DRB Application No.: 11DRB-70252 , Project # 1005354
Project Name: ARBOLEA DE VIDA + SAUNDYLL VILLAGE UNIT 2B
Agent: DEKKER PERICH SABATINI Phone No.:

DRB Application No.: <i>11DRB- 70265</i>	Project # <i>1005354</i>
Project Name: <i>Arbolera De Vida Unit 2B. Sawmill Village</i>	
Agent: <i>Dekker Perich Sabatini</i>	Phone No.:

**Re: Reason for Request
Sawmill Village
Request for Amended Site Development Plan for Subdivision
Tract 2-D of the Arbolera de Vida Subdivision, Albuquerque, NM (Phase 2)
Project # 1005354; 07EPC-00109**

SHEET NO.
SDP7

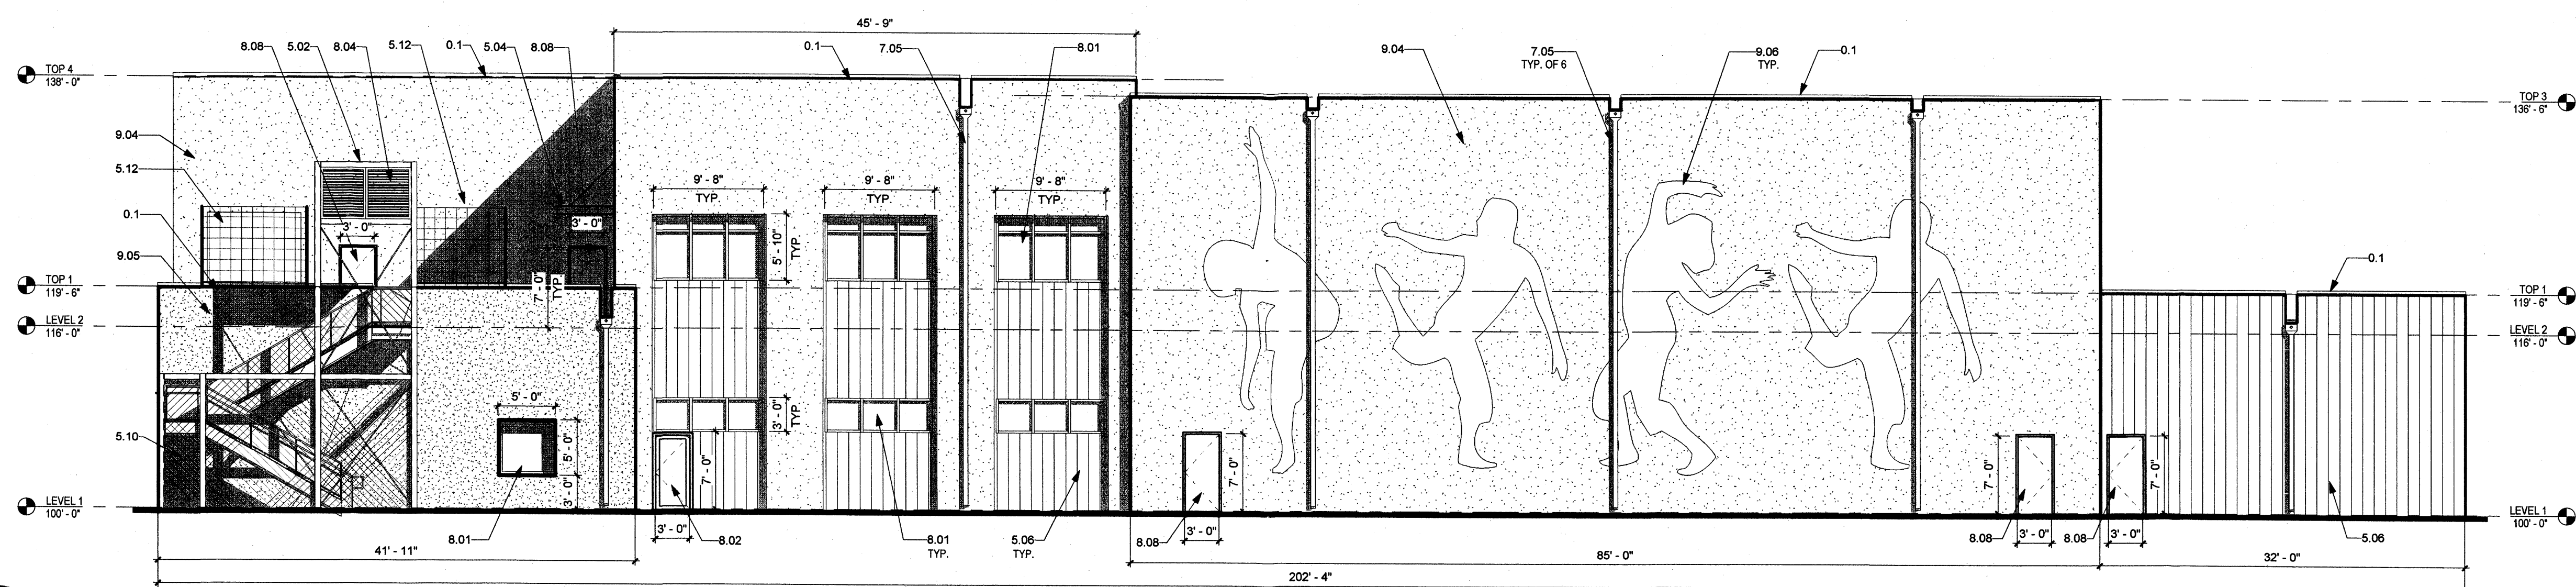
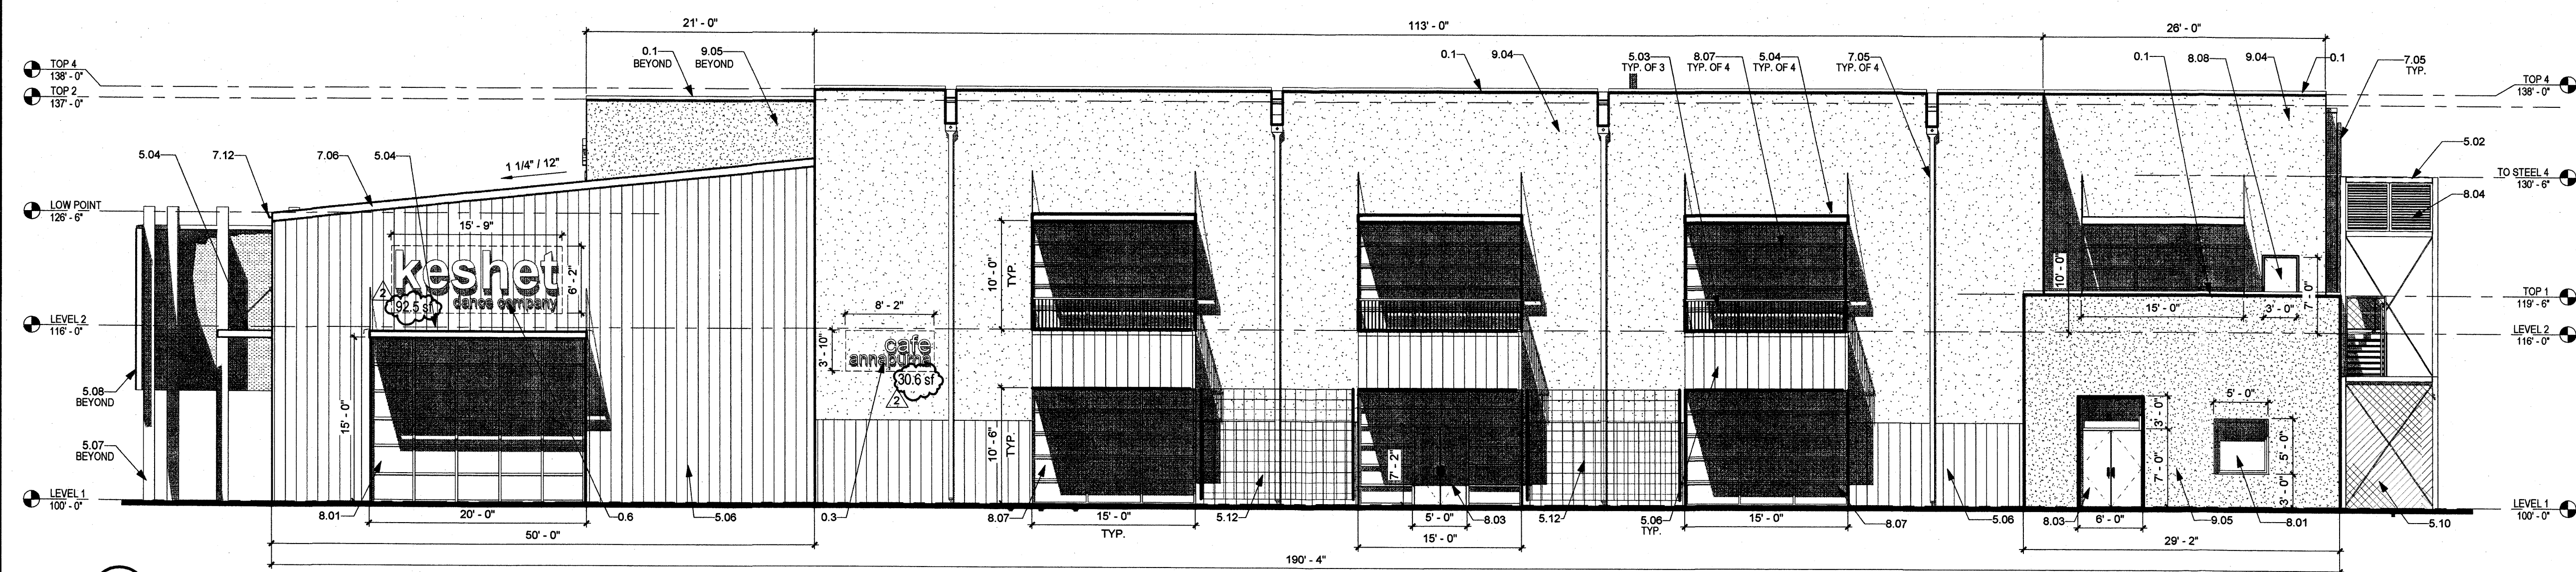
- b. The letter color and square footage of the building mounted signs shall be specified.

- c. Signs shall not be illuminated plastic panel signs (design standard).

RESPONSE: All has been indicated on the building elevations, sheets SDP7 and SDP7A.

RESPONSE: The note internally illuminated signs has been striked from sheets SDP7 and SDP7A.
